RE: Request for further information FG/90/26/HH

LOCATION PLAN 1:1250

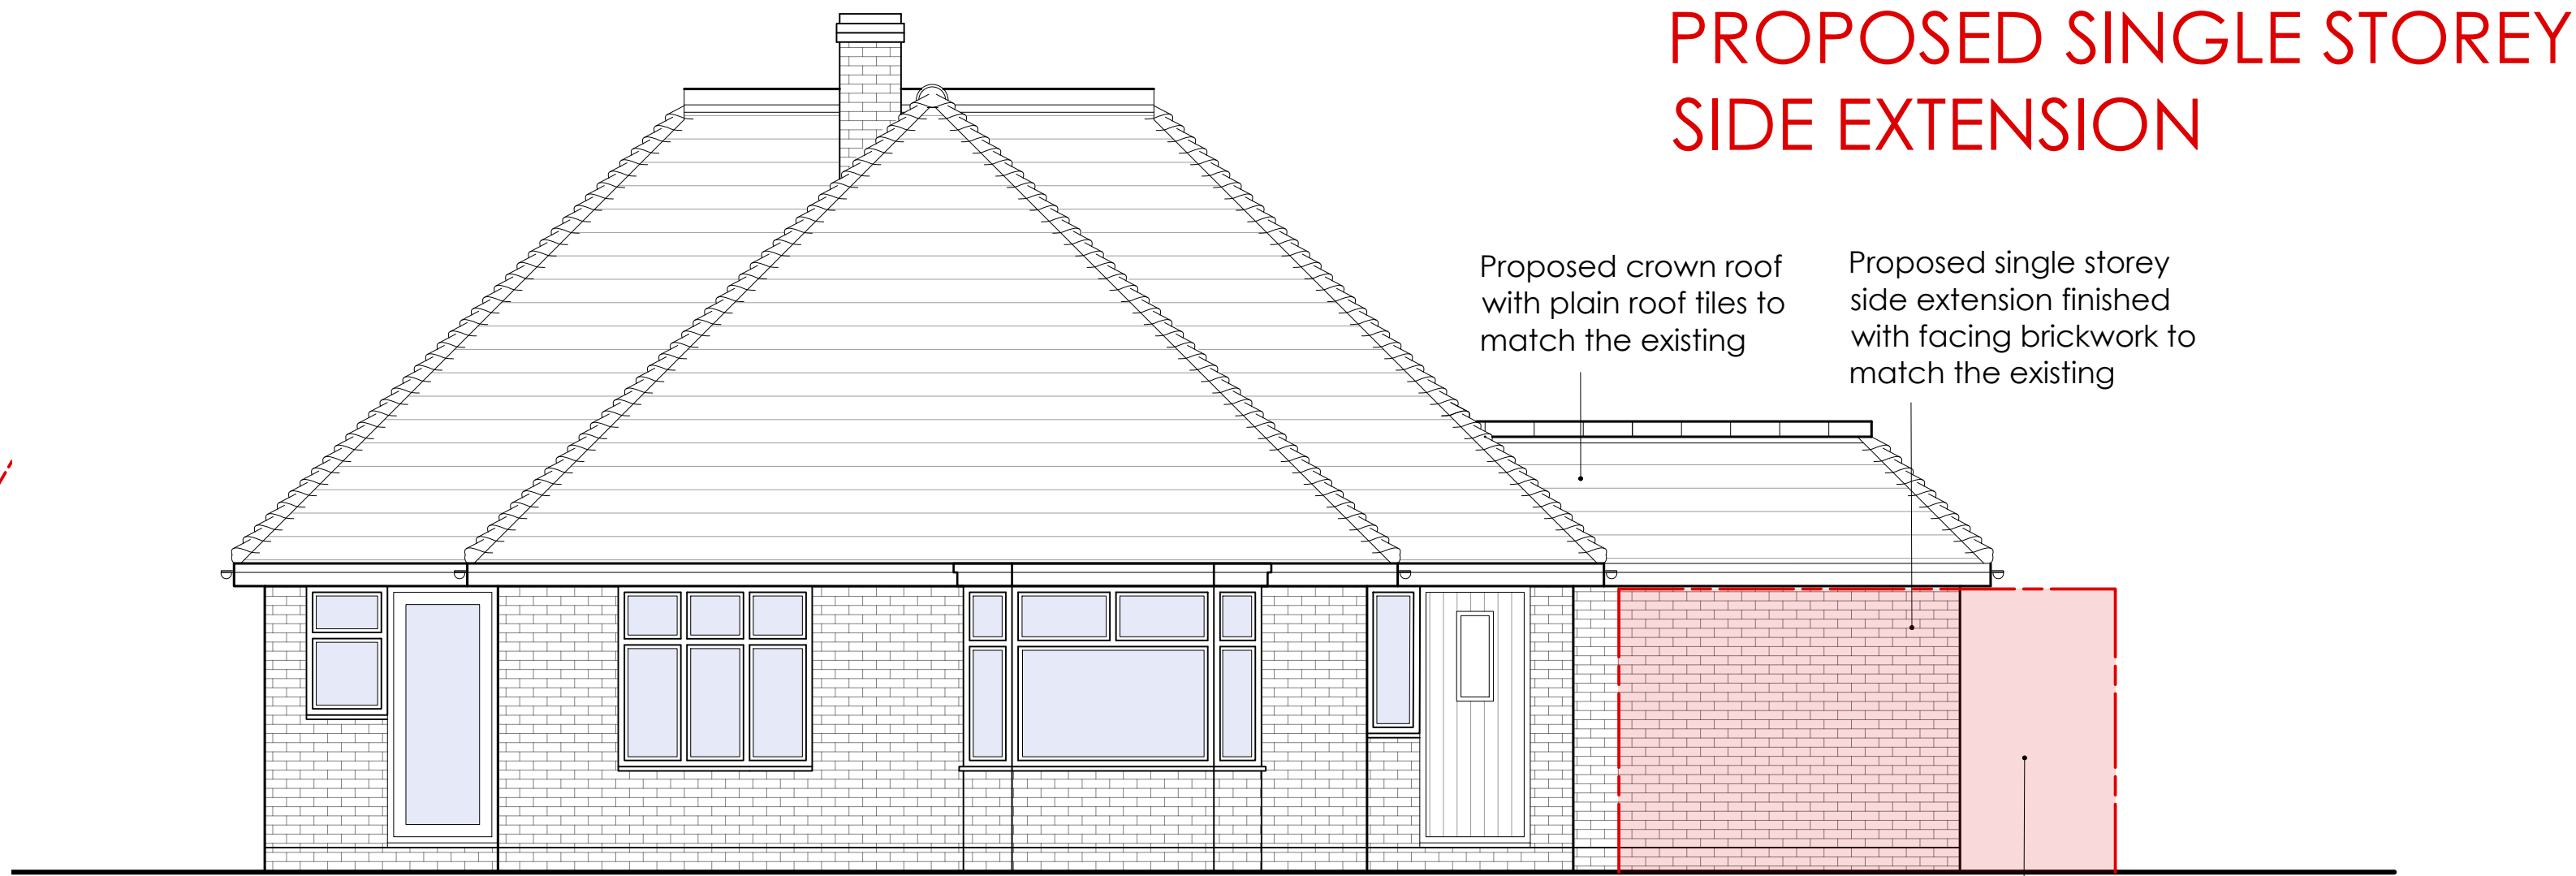
My apologies, I did not realise Upper west drive was also a private road, the red outline needs to include access to the site from a public road. I have attached the Householder Validation Requirements List, page 5 under "Location plan" outlines the requirements for the red outline. You can show this to the neighbours and hopefully they will be satisfied.

- The location plan red outline disconnects the proposed site from the road, it needs to look the same as the site plan photo below.

The nearest public road is about a mile away. Please let me know how I do that or can I just show the boundary of the house in red?

I have also attached the revised site / location plans showing one continuous red line. I must admit I don't really understand why this must be done as all the roads in South Ferring are private. We are now just linking one private road to another private road. As far as I can see it just adds confusion as the whole of South Ferring own and contribute to all the roads. I had a similar job close by, and all the neighbours got annoyed as it looks like the applicant is claiming that they own the road, which of course they don't. Can you just briefly explain why I have to include the road as I know the client and the neighbours will ask the question.
